From: Chris.Ritchie@planning.nsw.gov.au
Sent: Wednesday, 20 July 2016 2:32 PM
To: Reg Van Rij
Cc: rebecca.sommer@planning.nsw.gov.au
Subject: FW: Cobaki Estate - Project Approval 08_0200 Mod 2
Attachments: L_14-07-2016_DoP_C.Ritchie.pdf

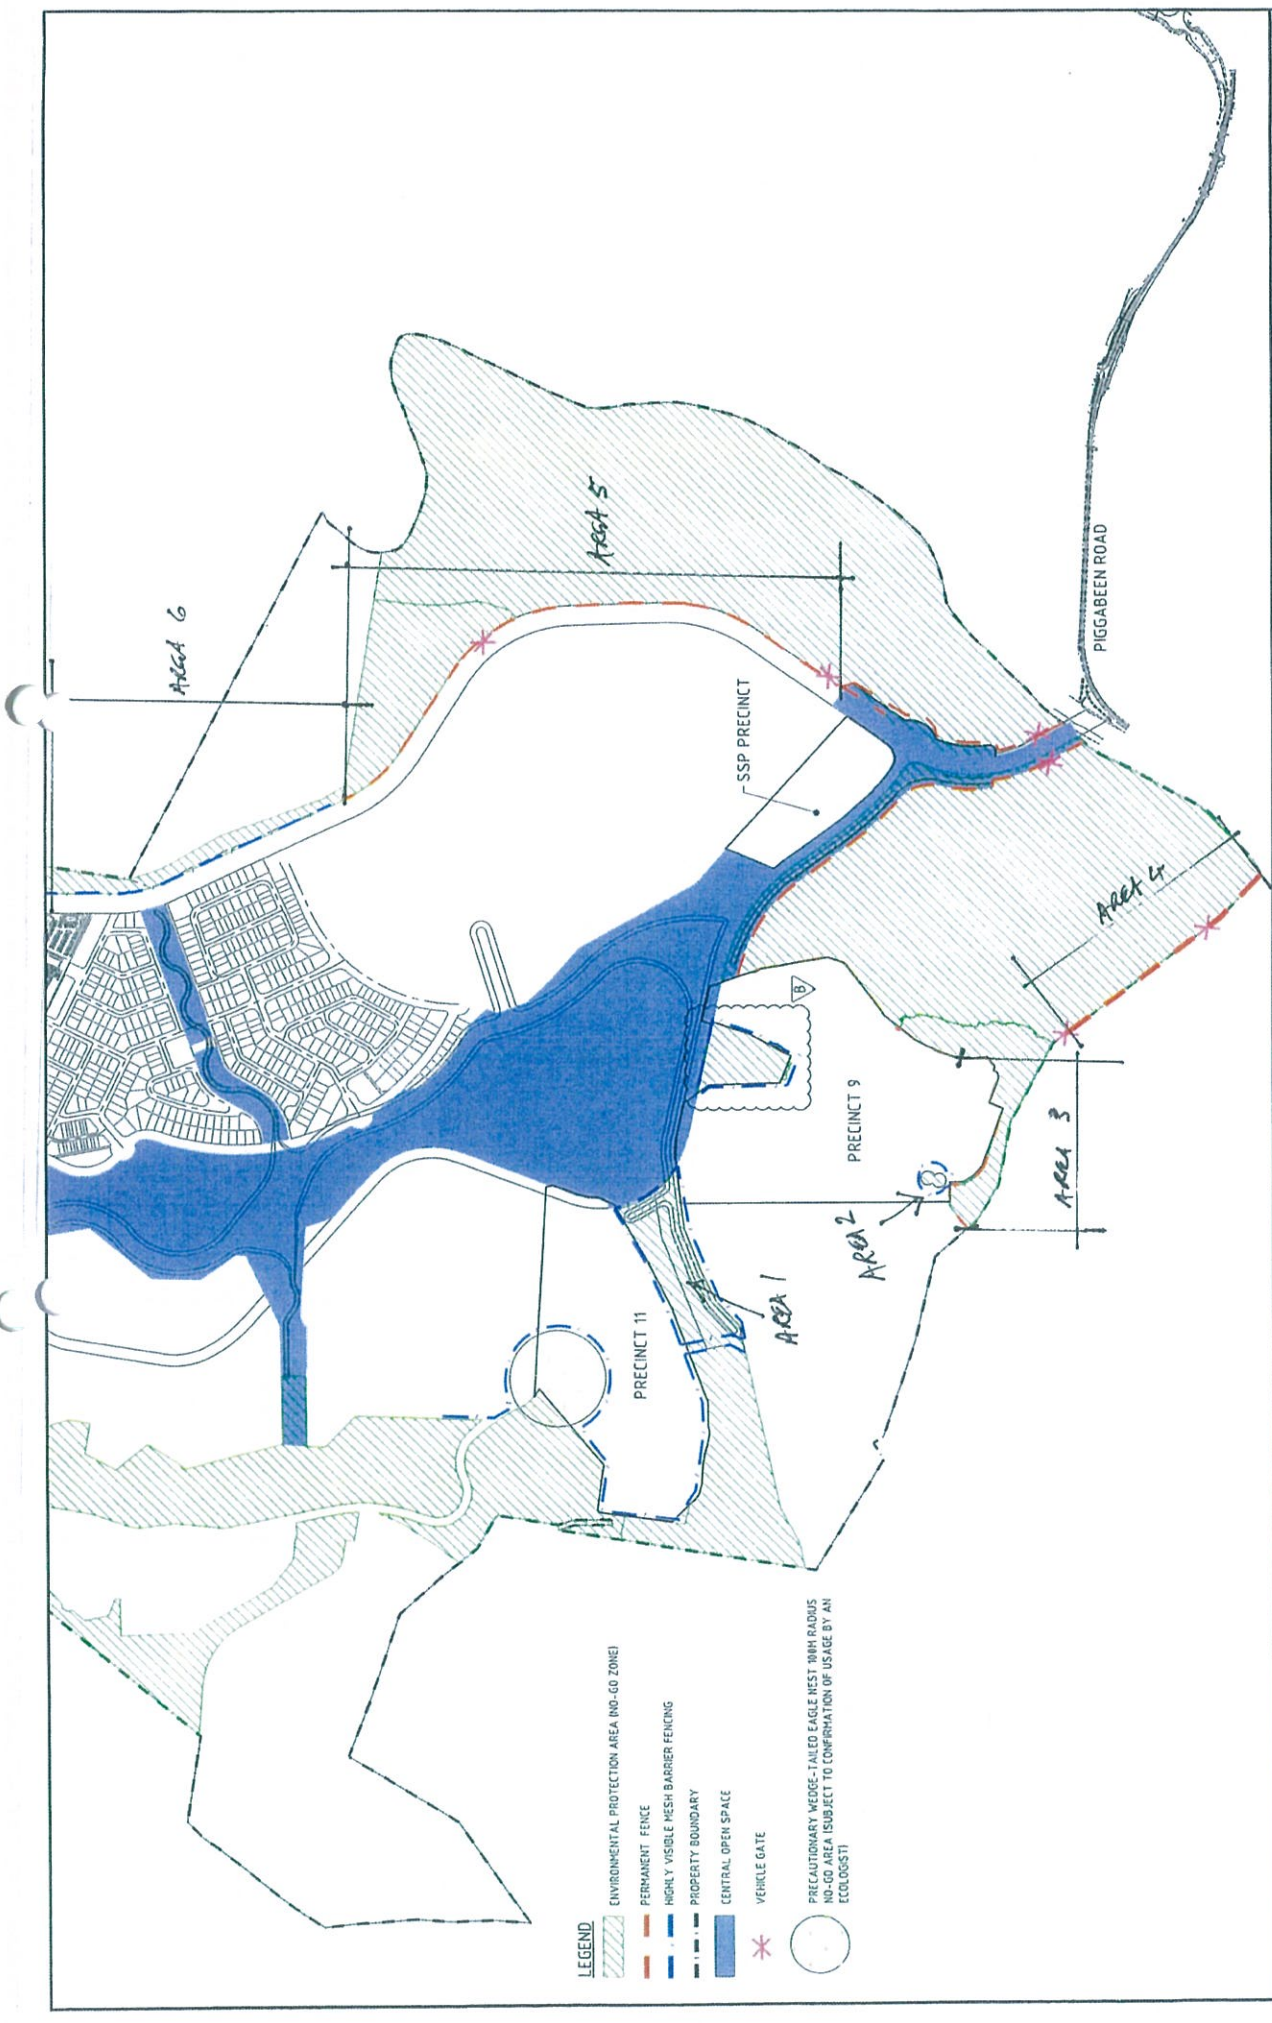
We have had a chance to review the information that you have provided in your letter dated 14 June 2016. In relation to Condition 39A, we request provision of **one** clear, detailed plan showing the existing approved fencing and the proposed alterations to the fencing plan for our consideration. This will allow the Department to understand the changes you are seeking given that the fencing, from my advice, is already installed.
